Rezoning Transportation Analysis

Petition Number: 2020-150

Revision Log:

Date	Description
11-30-20	First Review (EL)

SCHEMATIC
SITE PLAN

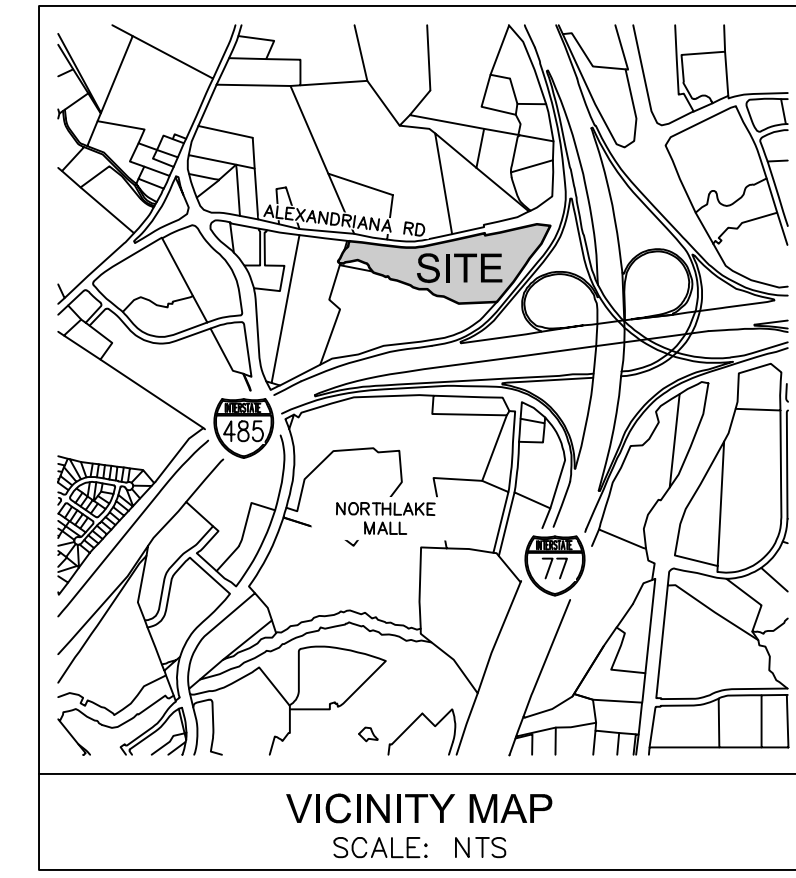
- a. **Alexandriana Road:** Location of curb and gutter needs to be installed at a location in coordination with NCDOT and CDOT. In reference to the North Lake Area Plan, the future cross section recommends a 4-lane divided facility with bike facilities. Coordinate with NCDOT (Stuart Basham) and CDOT to determine the right-of-way and asymmetric road widening needed for this future cross-section, while considering the following constraints: existing cemetery and Town of Huntersville jurisdiction limits to the north, future replacement/widening of Alexandriana Road bridge over I-77, etc. The total right-of-way width needed for this future cross section is 100-feet.

Label and dimension the curb and gutter from the centerline for each road on the site plan.

3. Revise the site plan and conditional note(s) to include the controlled-access (C/A) limits, to be provided by NCDOT.
4. Revise the site plan and conditional note(s) to commit to construct an 8-foot planting strip and pedestrian facility along Alexandriana Road per Chapter 20 of the City Code and Charlotte BIKES; CDOT requests a 12-foot shared use path. The site plan shall label and dimension both items from the back of curb and gutter and road centerline.
5. Revise the site plan and conditional note(s) to relocate the proposed access on Alexandriana Road to the private drive that is aligned with the proposed clubhouse, as permitted by sight distance constraints and NCDOT request to shift this access further away from the C/A limits.

6. Revise the site plan and conditional note(s) to restrict the proposed western access on Alexandriana Road to right-in/right-out, as required by NCDOT.
